LAND EAST OF TYE LANE,

WALBERTON

DESIGNERS RESPONSE – STAGE 1 ROAD
SAFETY AUDIT

REPORT REF NO. 183248-08

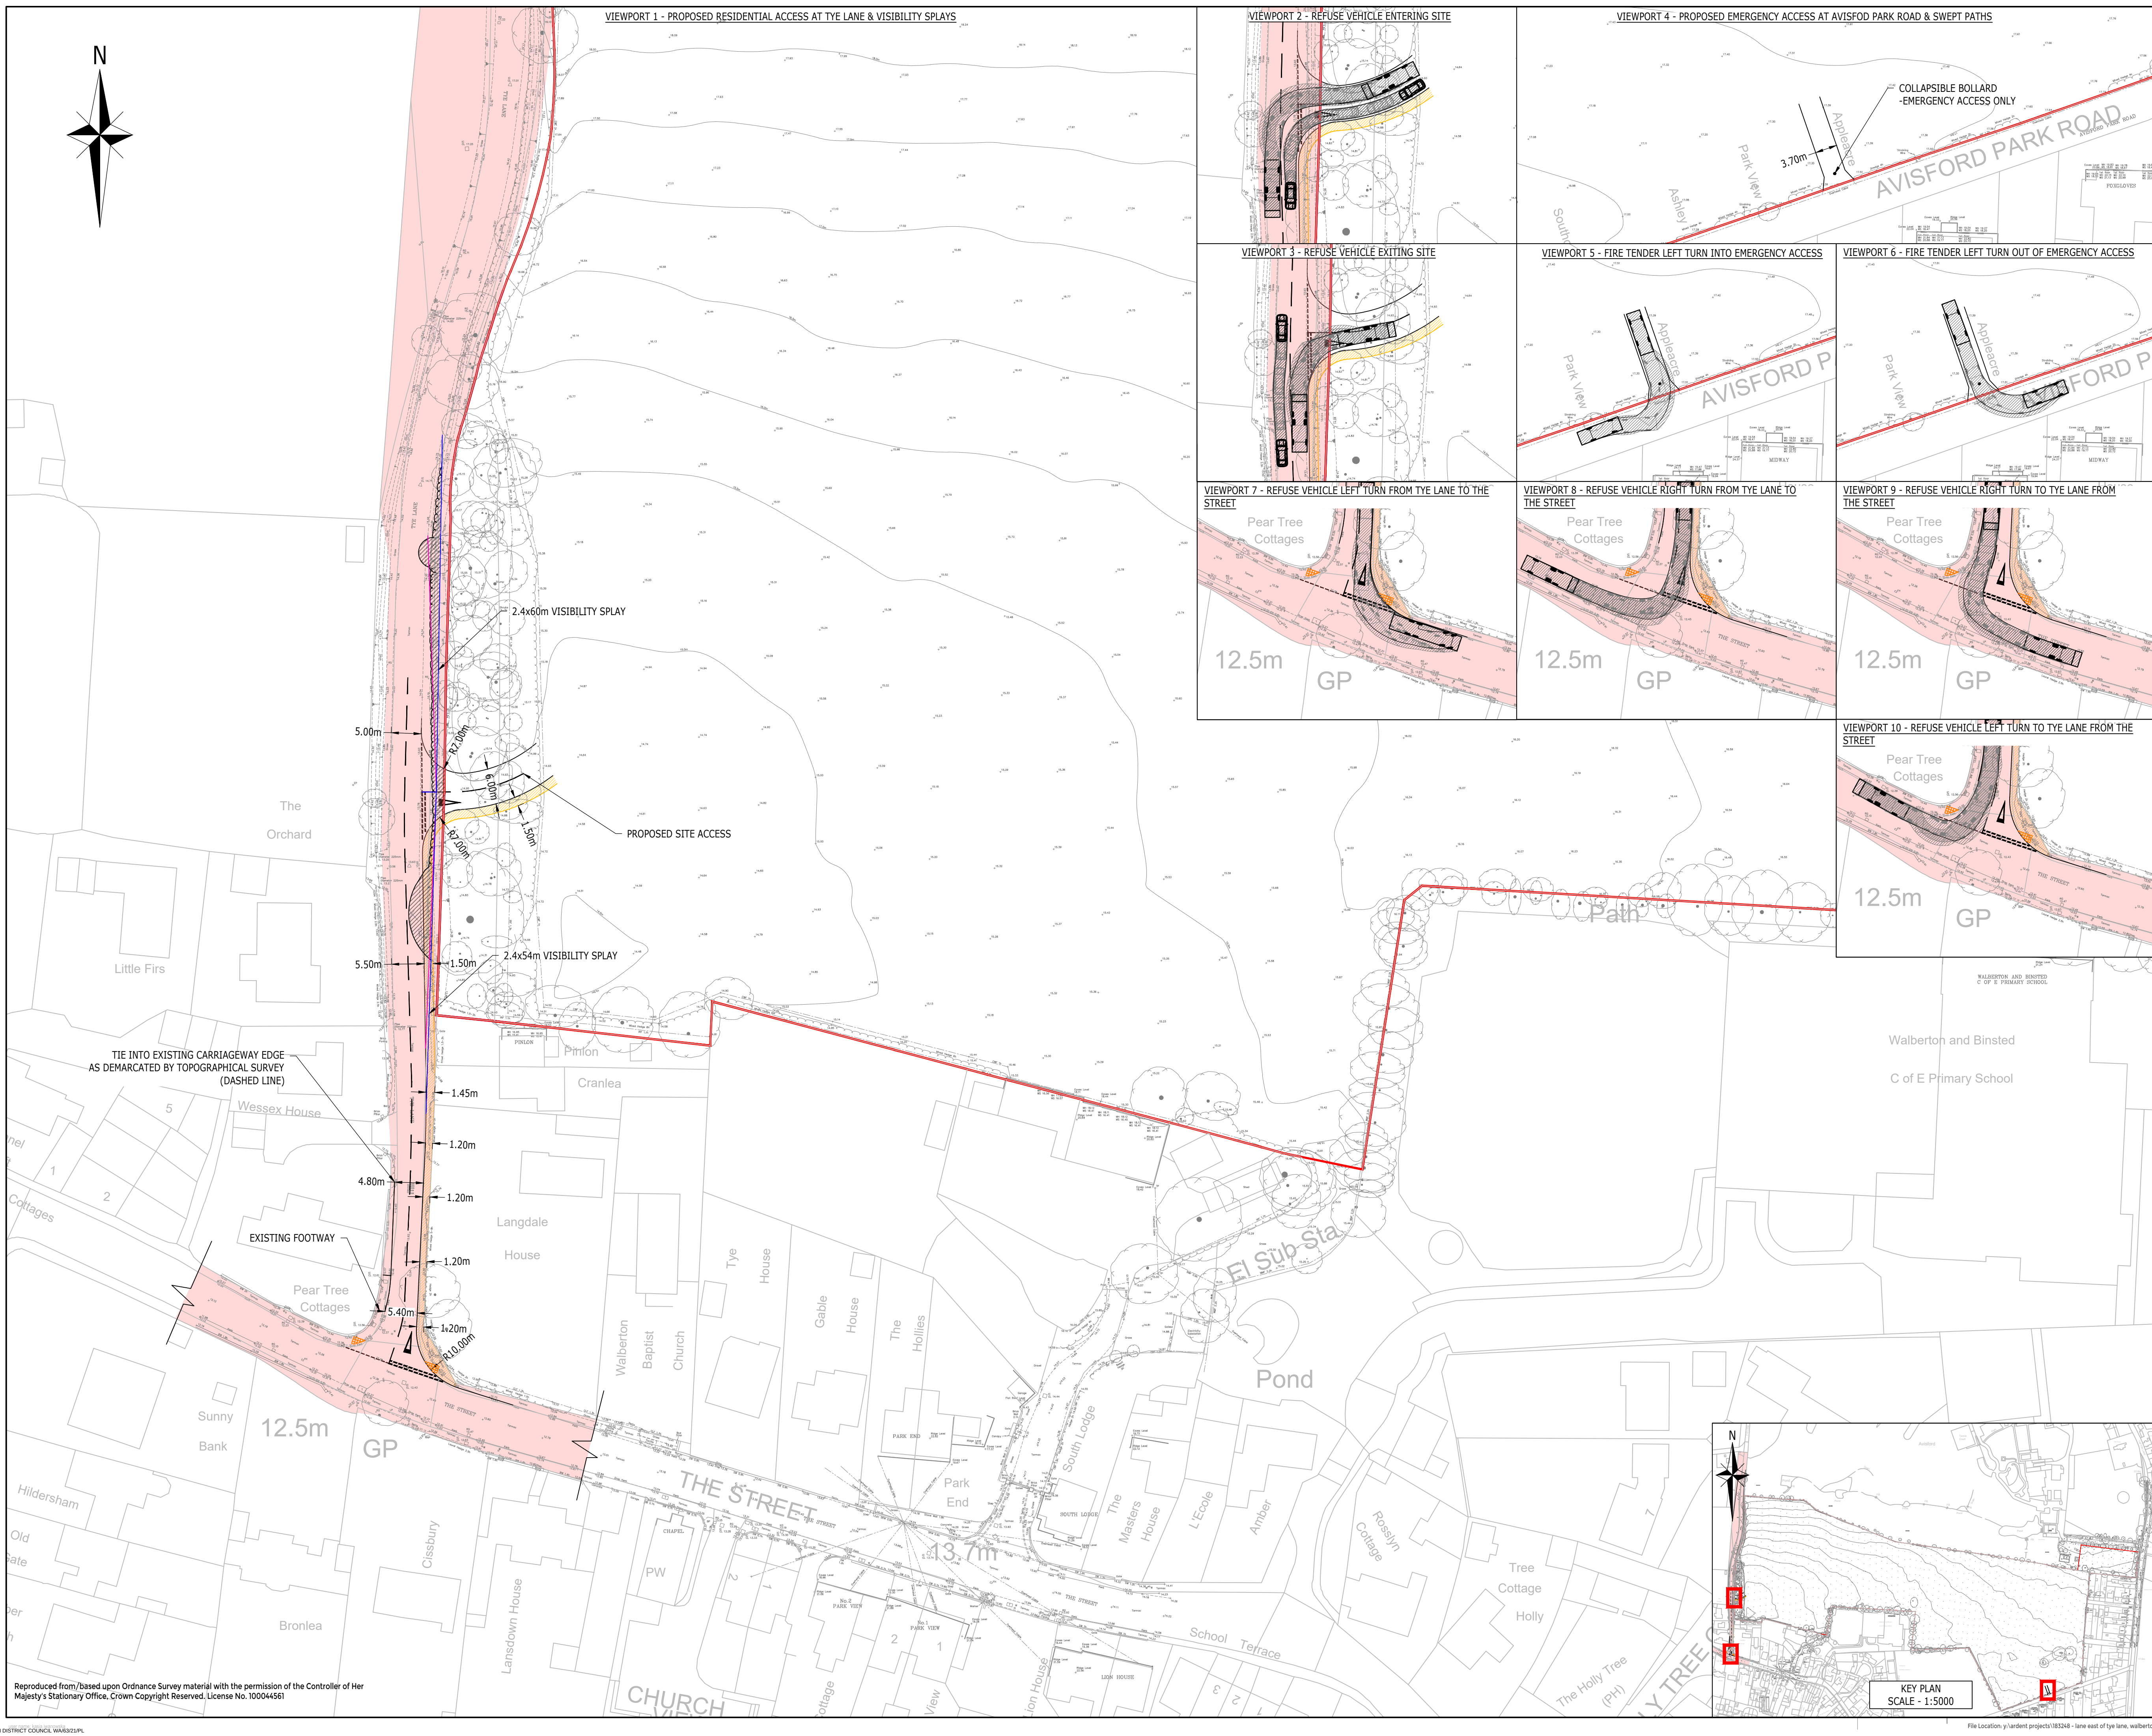
RSA problem	RSA recommendation	Design organisation response	Overseeing Organisation response	Agreed RSA action
Lack of vertical profile information could lead to overshoot collisions	It is recommended that the vertical alignment details of the access should be provided for assessment at Safety Audit Stage 2.	Details will be provided for Stage 2 Audit. However, in accordance with DMRB CD123, the gradient on the access road approach to Tye Lane will not exceed 4% over a distance of 15 metres (measured from the edge of Tye Lane).	Details of vertical alignment to be provided at detailed design/ for stage 2 RSA.	Vertical alignment to be provided for Stage 2 RSA.
Restricted visibility could lead to side impact collisions or rear end shunts.	It is recommended that there should be no physical obstruction of the visibility splays and additionally, that the splays should be periodically maintained to retain visibility.	Agreed and necessary visibility splays will be maintained as appropriate. The assessed ACE Drawing 183248-002E shows that the area of vegetation within the splay will be removed in order to maintain visibility. On-going vegetation maintenance will be the responsibility of West Sussex Highways.	Visibility splays to be removed of vegetation and maintained.	Visibility splays are to be maintained to ensure they are clear of vegetation as required.

Insufficient carriageway space could lead to side swipe collisions	It is recommended that the junction should be eased to allow access and egress by large vehicles without incursion into opposing lanes by the more frequent usage vehicles; unless in line with CD123, these movements form only a small percentage of vehicle movements.	It is noted that the Overseeing Organisation did not previously raise any concerns with the swept path of larger vehicles, noting that such an occurrence would be infrequent. Nevertheless, swept path analysis has been incorporated into ACE Drawing 183248-002G demonstrating the manoeuvres of a large refuse vehicle. This will be a very infrequent occurrence given only a weekly collection service is typically carried out for residential properties and as such does not represent a significant safety risk in our opinion.	Vehicle tracking has been provided and shows a refuse vehicle would over run the centre line of the junction of Tye Lane and The Street, given the low speed environment and low level of existing trips circa 900 per day (2018 count) on Tye Lane which would be making the movement of which only a small % would be heavy vehicles then no further concern is raised.	Item resolved no further action required.

Presence of a ditch may compromise pedestrian safety	It is recommended that details of how the ditch is to be accommodated or barriered off should be provided for assessment at Safety Audit Stage 2.	Details will be provided for Stage 2 Audit.	Details to be provided at detailed design/for stage 2 RSA	Details will be provided for Stage 2 Audit.
Insufficient intervisibility could lead to lead to vehicle to pedestrian collisions.	It is recommended that the intervisibility splay should not be obstructed and that the hedge line should be cut back.	We agree with the Auditor recommendation. Hedge line will be cut back as part of junction improvement works.	Vegetation to be cut back to the edge of the highway.	Vegetation will be cut back to the edge of the highway.

Summary: Lack of vertical profile information could lead to overshoot collisions.

There is an existing vertical level difference between the site and Tye Lane, where no vertical alignment details were provided at the time of the audit. There is concern that inappropriate vertical profiles could lead to overshoot collisions at the junction.

It is recommended that the vertical alignment details of the access should be provided for assessment at Safety Audit Stage 2.

The visibility splays are obstructed by vegetation and trees, see figures 1 and 2 overleaf. Restricted visibility could lead to side impact collisions or rear end shunts.

It is recommended that there should be no physical obstruction of the visibility splays and additionally, that the splays should be periodically maintained to retain visibility.

Summary: Insufficient carriageway space could lead to side swipe collisions.

No swept path information has been provided for assessment, where the junction mouth is being narrowed due to the proposed footway provision. Insufficient turning space may lead to larger vehicles entering the opposing carriageway. This could lead to possible side swipe collisions or head on collisions; however, in CD123 'Geometric design of at-grade priority and signal-controlled junctions' under paragraph 5.2 it is stated that:

It is recommended that the junction should be eased to allow access and egress by large vehicles without incursion into opposing lanes by the more frequent usage vehicles; unless in line with CD123, these movements form only a small percentage of vehicle movements.

Summary: Presence of a ditch may compromise pedestrian safety.

The proposed footway places pedestrians closer to the edge of a drainage ditch, where there are no proposals to fence off the ditch, which could lead to pedestrians falls, particularly during the hours of darkness. A lack of luminance could lead to pedestrians being unaware of the edge of the ditch and could lead to pedestrians falling into the ditch.

It is recommended that details of how the ditch is to be accommodated or barriered off should be provided for assessment at Safety Audit Stage 2.

A footway is proposed, which will involve junction realignment and will likely improve the pedestrian / traffic intervisibility at the proposed pedestrian crossing point on the eastern side of the carriageway at the junction. However, there is concern that the hedgerow to the north will still restrict intervisibility for pedestrians crossing, see figure 3 below, where restricted visibility could lead vehicle to pedestrian collisions.

It is recommended that the intervisibility splay should not be obstructed and that the hedge line should be cut back.
